INDEPENDENT MONITORING PANEL FOR SPRINGVALE MINE

ADVICE RE:

**SPRINGVALE COAL MINE
EXTRACTION PLAN
LONGWALLS 428-432**

November 2021

Figure 1: LW428-430 Mine Plan and Approved LW430 Commencing Position at Cut-Through 11

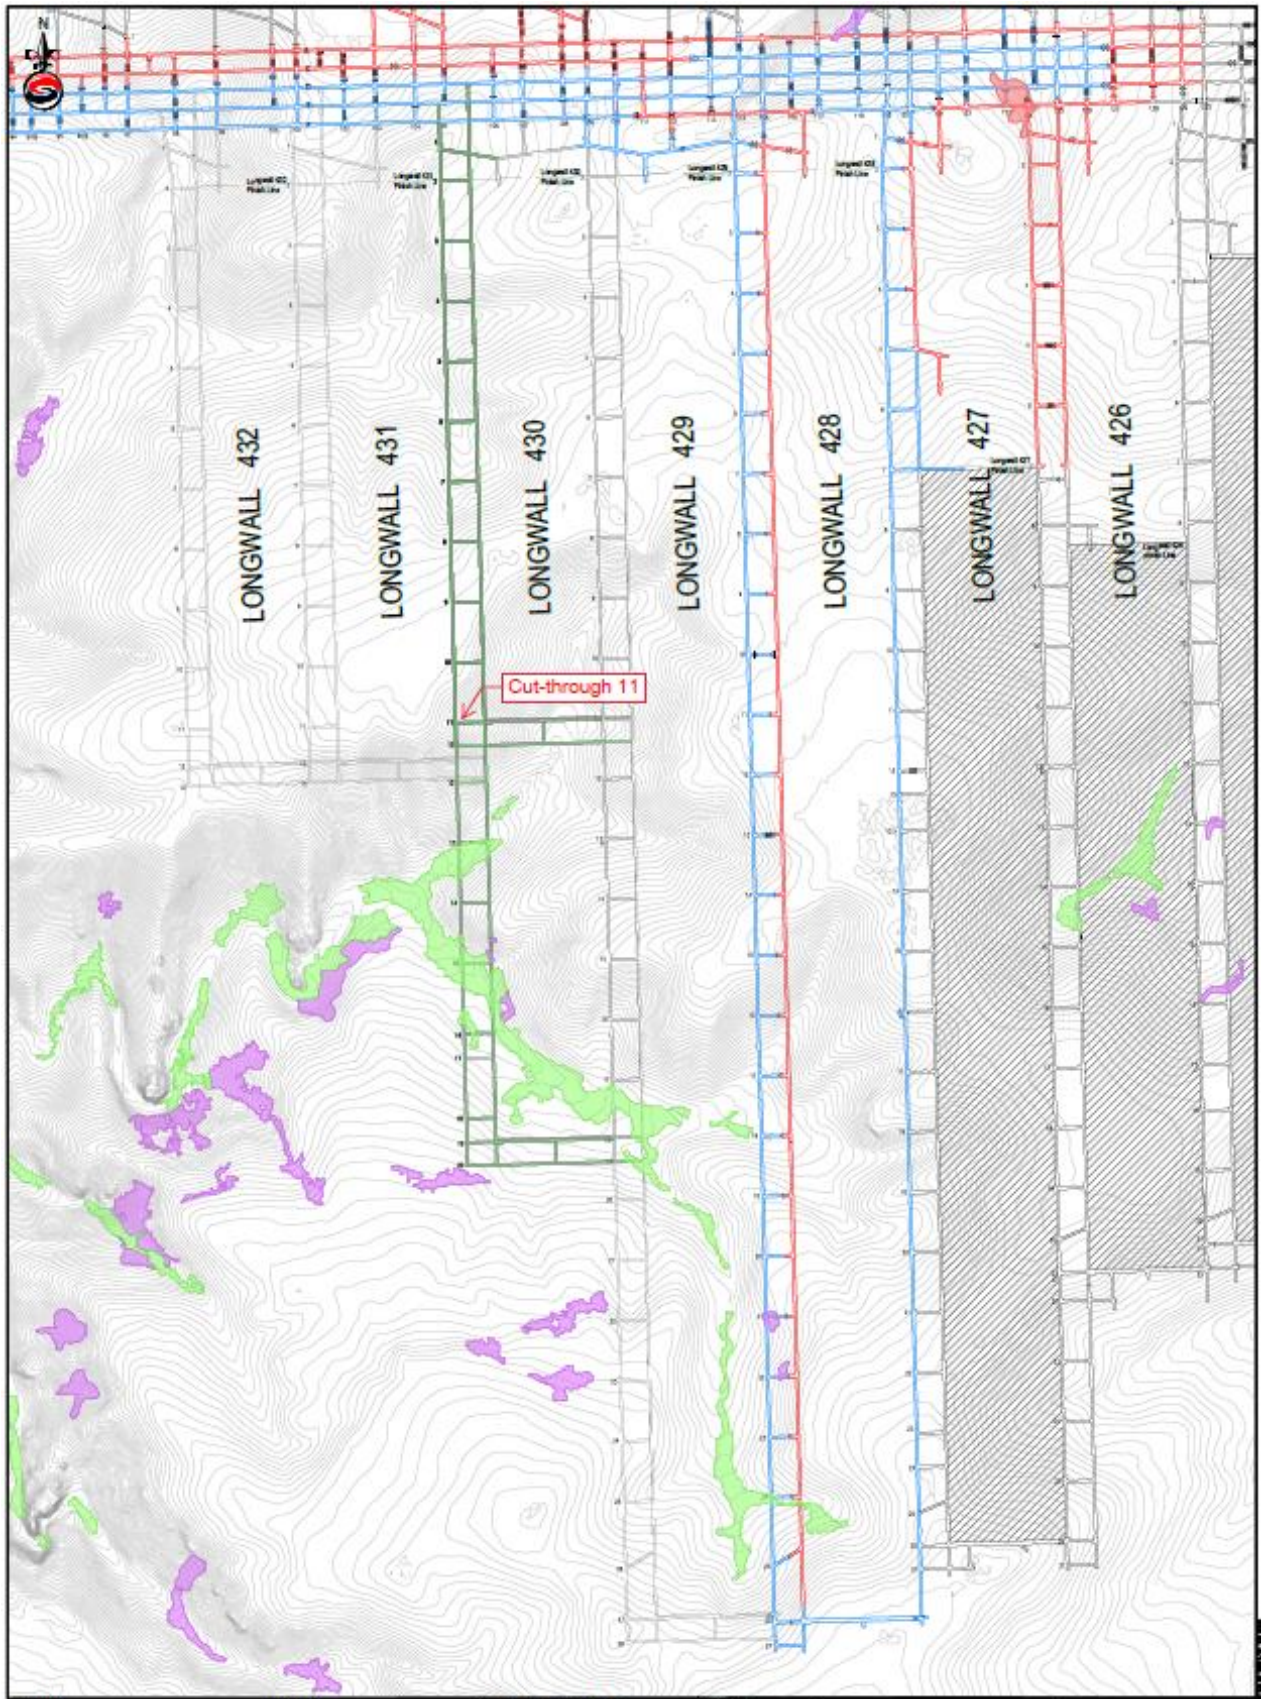
- The length of LW430 should also be reduced so that, at the very least, Marrangaroo Swamp and Marrangaroo Creek fall outside the angle of draw of this longwall panel. This action would also reduce the likelihood of direct and indirect impacts to hanging swamps in the area.

- The length of LW430 should also be reduced so that, at the very least, Marrangaroo Swamp and Marrangaroo Creek fall outside the angle of draw of this longwall panel. This action would also reduce the likelihood of direct and indirect impacts to hanging swamps in the area.

Figure 1: Centennial's Amended Mine Plan

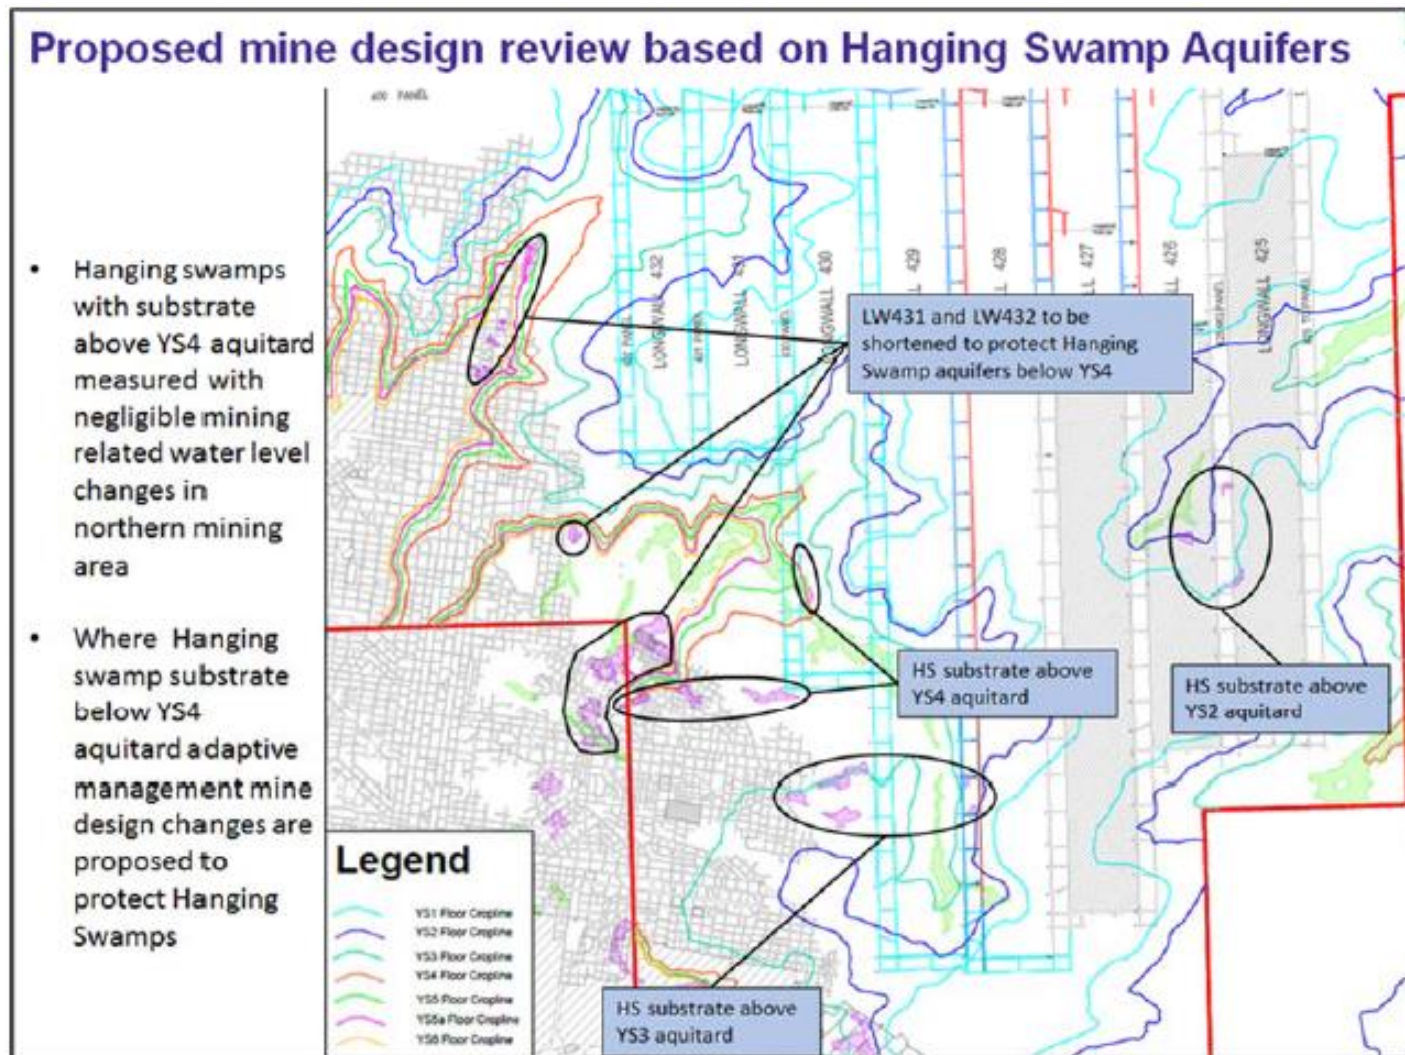
- The proposal by Centennial Coal to reduce the lengths of LW431 and LW432 also goes some way to mitigating adverse environmental impacts on Marrangaroo Swamp and Marrangaroo Creek, subject to how the high permeability zone recently intersected immediately to the south of these panels behaves. Centennial Coal has advised that the zone is still under investigation.

- The proposal by Centennial Coal to reduce the lengths of LW431 and LW432 also goes some way to mitigating adverse environmental impacts on Marrangaroo Swamp and Marrangaroo Creek,
